Planning Inspectorate

Application by RWE Renewables UK Dogger Bank South (West) Ltd and RWE Renewables UK Dogger Bank South (East) Ltd for an Order granting Development Consent for the Dogger Bank South Offshore Wind Farms (Ref: EN010125)

Action points arising from Day 2 of the Issue Specific Hearing 2 on 16 January 2025

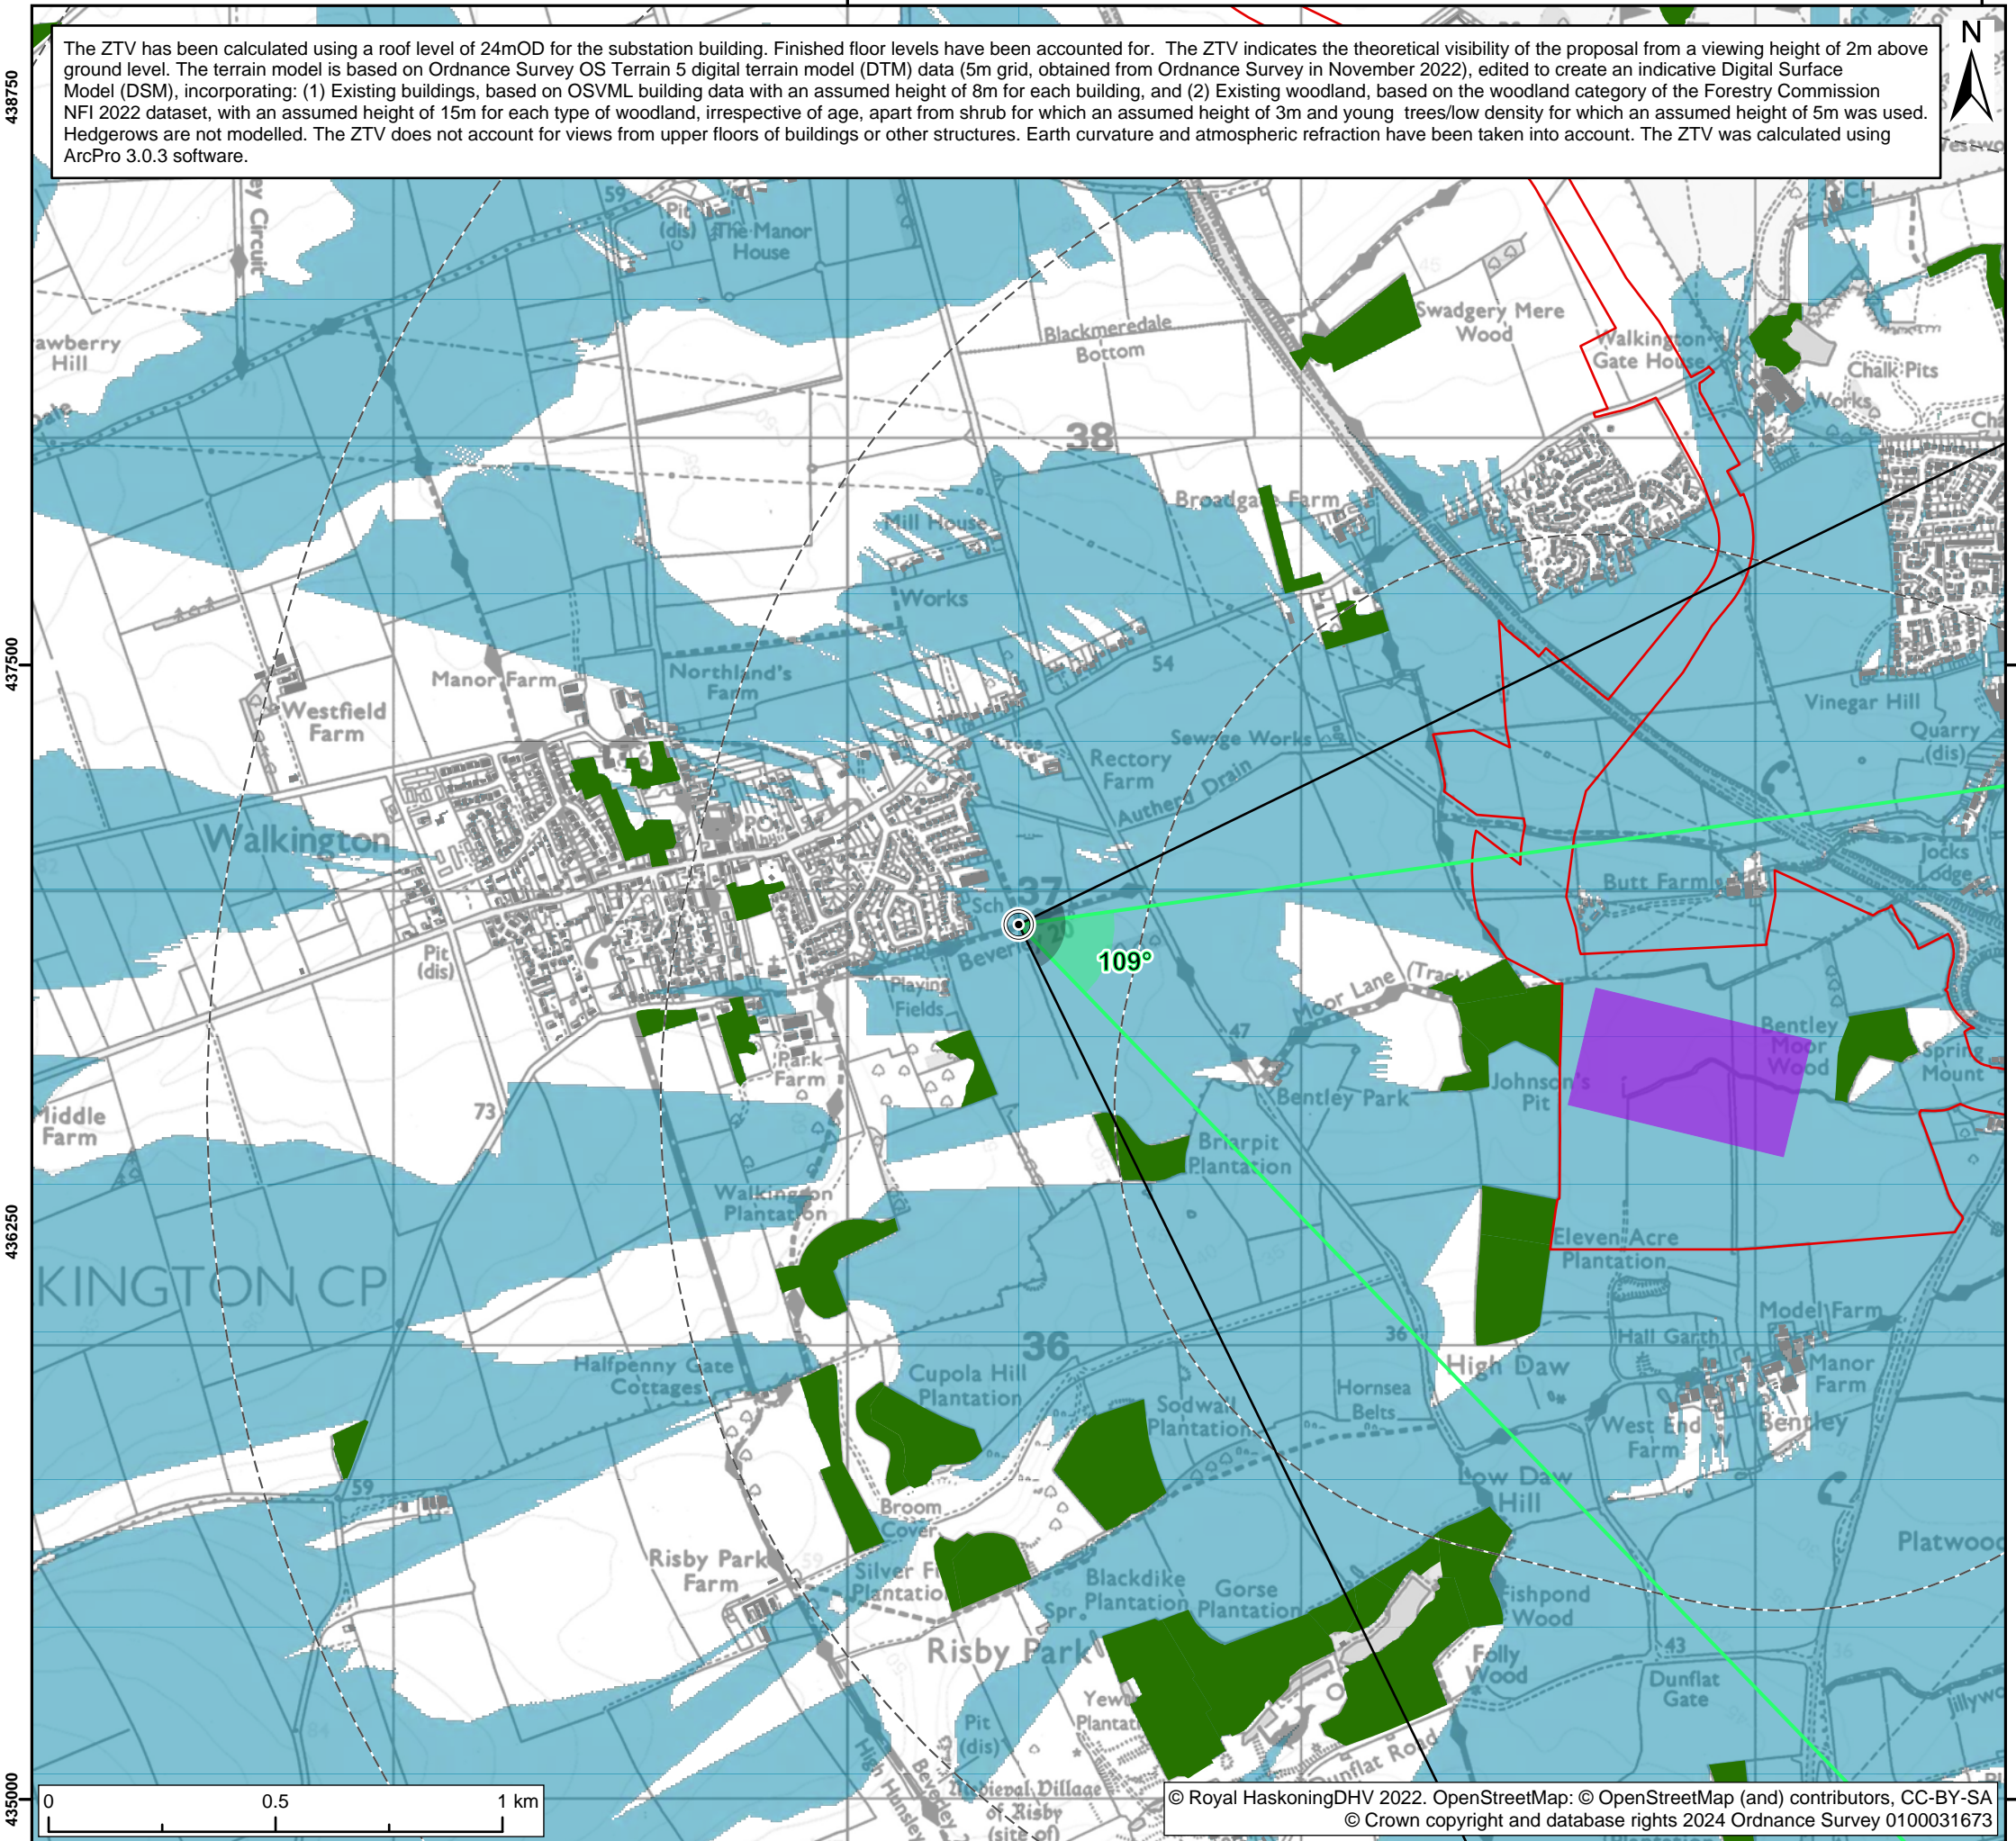
Action No.	Directed to	Question
		switch gear design to accord with the Landscape and Visual Impact Assessment. Please review this matter.
WQ12	The Applicants	Does the draft DCO [AS-120] or its supporting documents ensure that the converter station buildings would be constructed to the south of the converter station area marked on the works plans? If not, has the ES assessed the worst-case scenario if the converter station buildings were to be built closer to the scheduled monument at Butt Farm than as shown on indicative plans?
WQ13	The Applicants	Figure 23-15b1 [PDA-010] shows that there would be no views of the proposed converter stations from Blackmill. However, paragraph 309 of ES Chapter 22 [AS-092] suggests that there would be “varying visibility” of the converter station likely. Why is there this discrepancy and would there be views of the converter stations from Blackmill and the scheduled barrows? If there are would figure 23-15b1 need to be updated?
